75 Breezehill Avenue and 35 Laurel Street

UDRP Report
Official Plan and Zoning By-law Amendment
June 12, 2025

75 Breezehill and 35 Laurel
Response to UDRP Comments
Official Plan Amendment (D01-01-24-0027) and Zoning By-law Amendment (D02-02-24-0088)

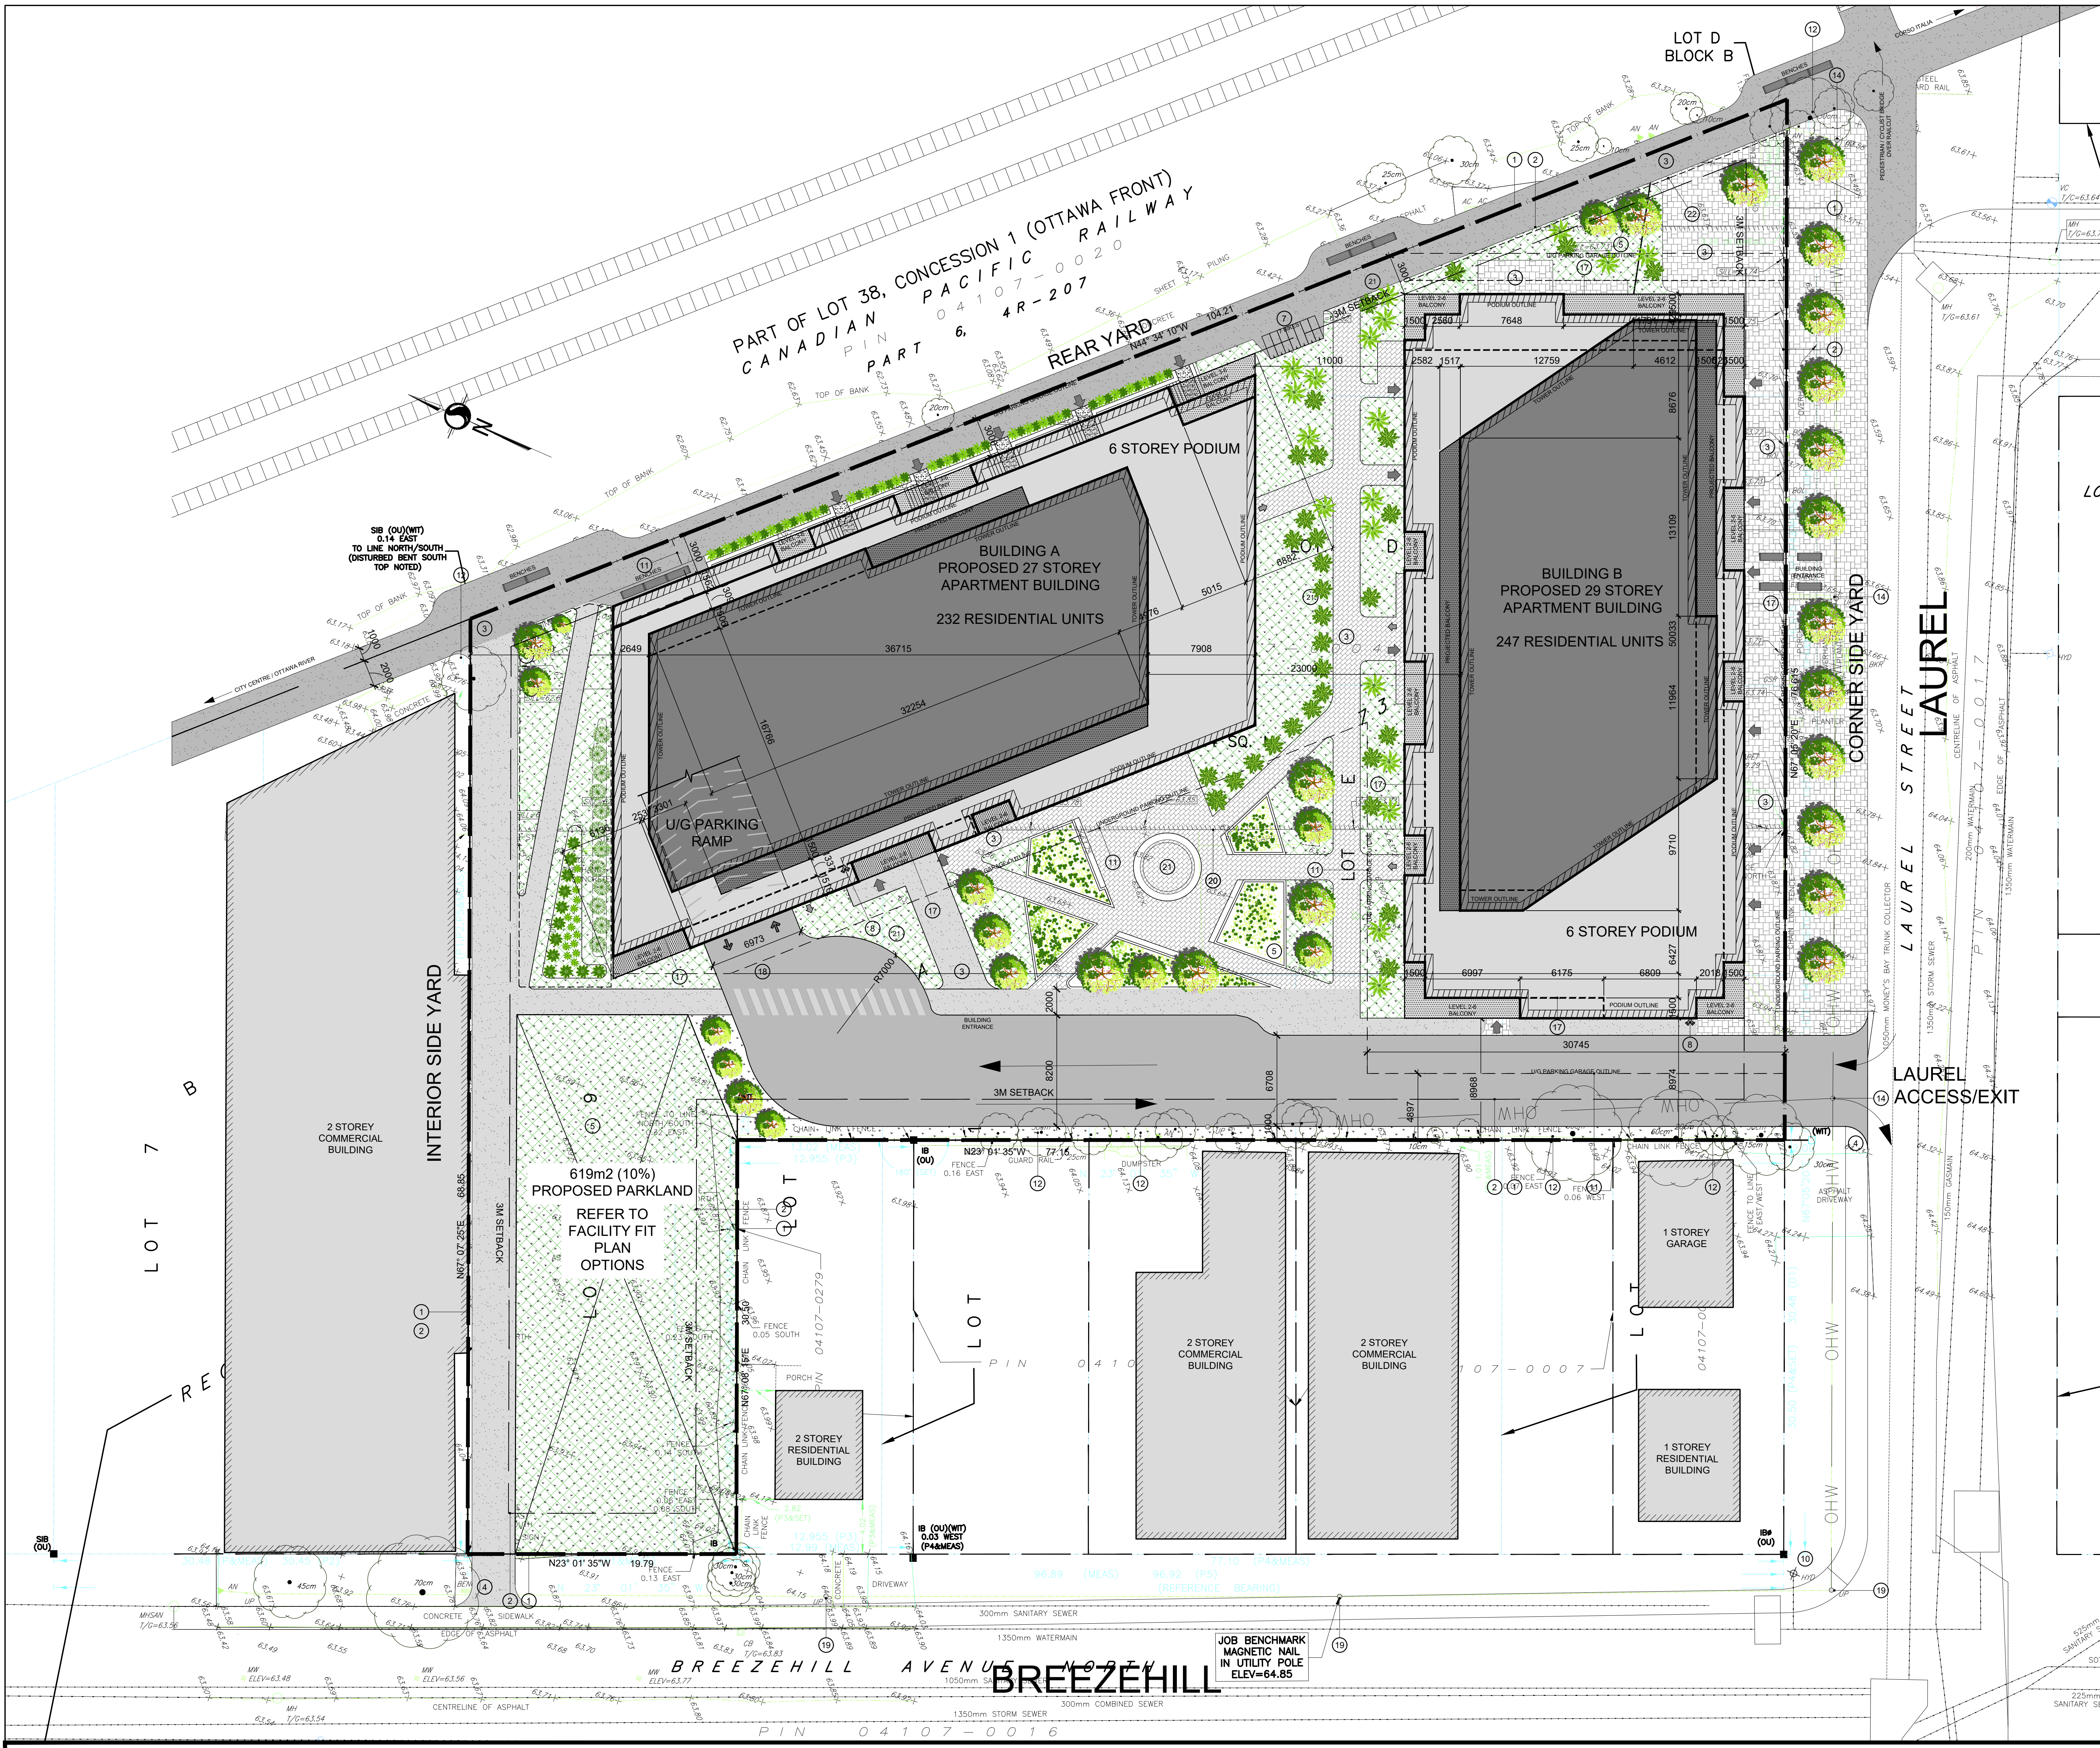
8.a)	The Panel suggests further study is required to justify the current proposed location of the park.		Noted. The park location is optimal for the site as it makes use of a section of the site that would otherwise be challenging to put to good use.

8.b)	Consider the park as an integrated component within the proposal and not an arm off the end of the property.		The park as proposed is an integral component of the site and, although located on the edge of the property. Planned pathways provide connectivity between this park and the site and this park serves as a vital component of the overall amenities provided through the proposed development.
9	The Panel recommends considering patios and accessible pedestrian spaces instead of extensive garden beds in the landscaping.		Noted

15	The Panel has concerns with the relationship between the two podiums being too tight and narrow.		The site plan allows for ample separation between the two podiums. This space features a pedestrian walkway and plantings.

15.a)	Consider alternative massing that alleviates that condition.		Noted.
15.b)	Explore a variety of options for a single-tower site with a strong podium.		A single tower does not efficiently program the space provided by the site and would represent and under-provision of much needed residential housing density in an identified strategic growth area near services, amenities, and rapid transit. In order to respond to the ongoing housing crisis, it is important to optimize the provision of residential density on this site.
16	The Panel is not supportive of the proposed two-tower approach.		Noted.
